Greenvale LRD
 Dublin

**Letter to NTA 08th February 2024
- Response to the NTA's Email**

RESPONSE TO THE NTA'S EMAIL RECEIVED ON THE 15th December 2023

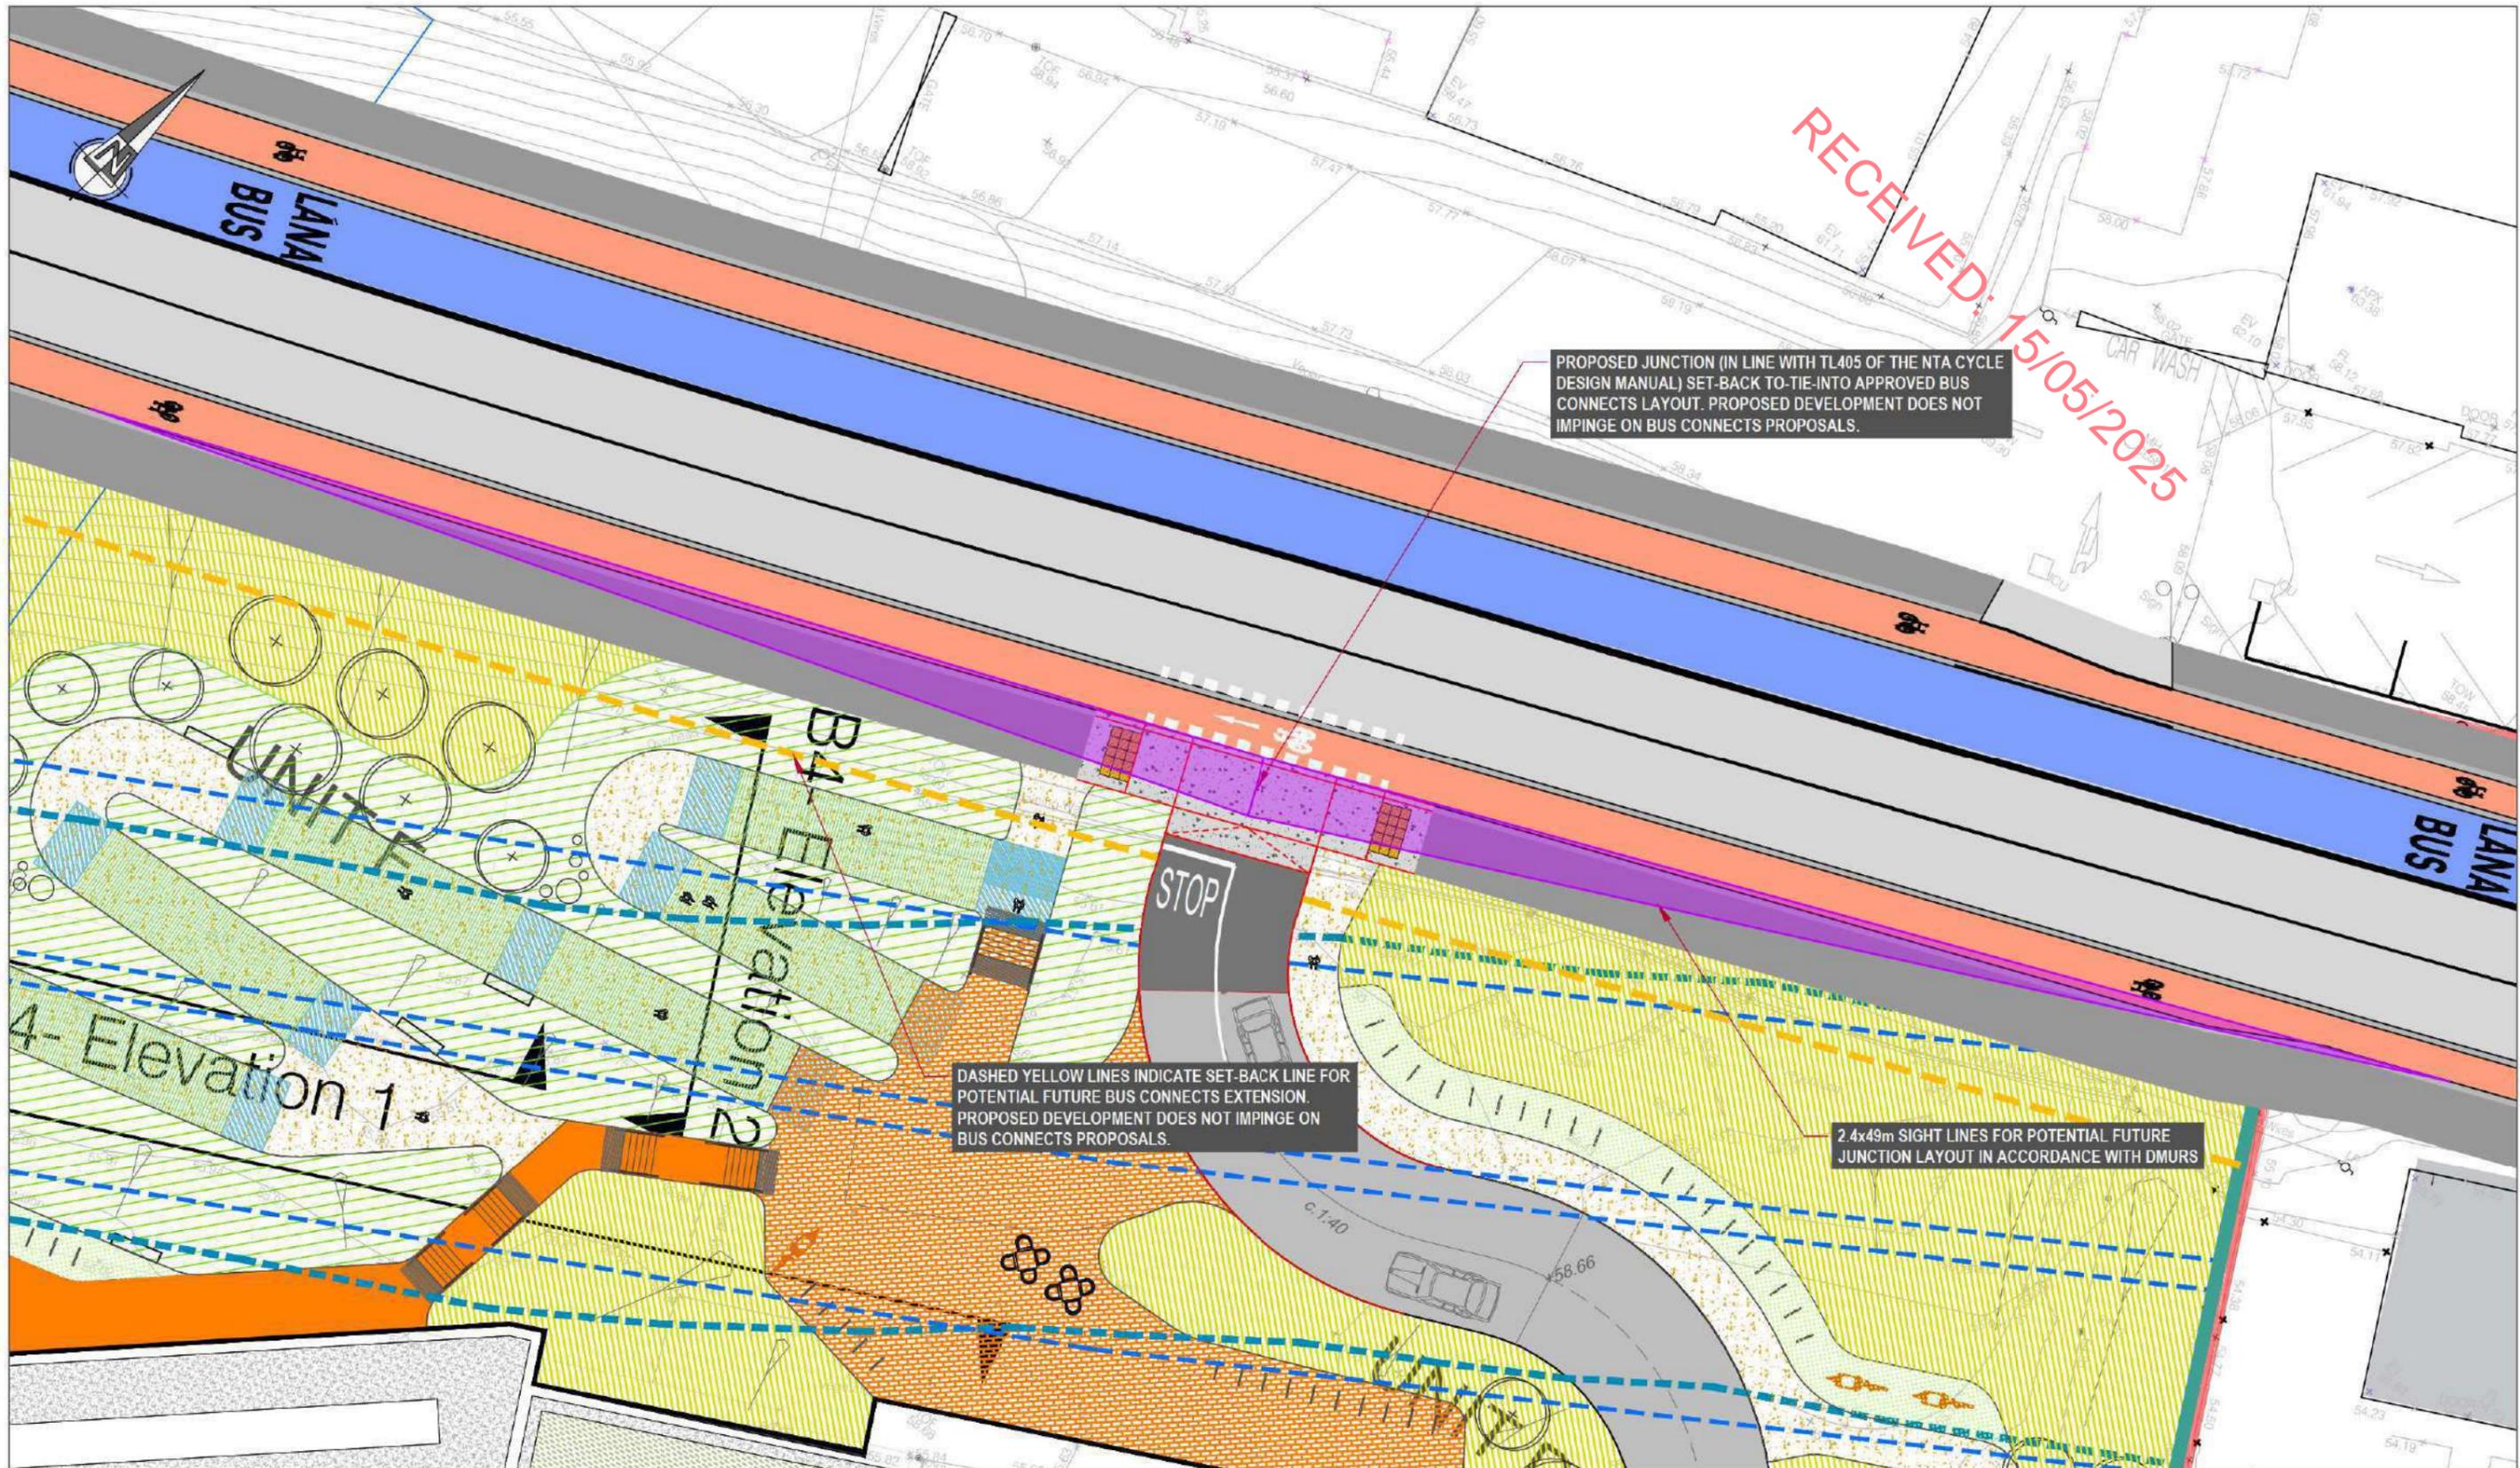
I've attached our updated TA drawings. TA drawings 007 & 008 have now been updated to show the approved BusConnects scheme (i.e. without a bus lane past our site). However, we also show a dashed yellow line which indicates a set-back line for a potential future bus lane (subject to a future planning application).

The NTA Bus Connects team have reviewed the revised drawings and are satisfied that the drawings now reflect the current approved Core Bus Corridor alignment for the Tallaght/ Clondalkin to City Centre Scheme. They are also satisfied that the technical note reflects the requirement for the developer to liaise with the BusConnects team to coordinate the setting out details of the junction into the development to ensure any rework is limited and all tie-in works can be undertaken with the approval permanent/ temporary land take boundaries.
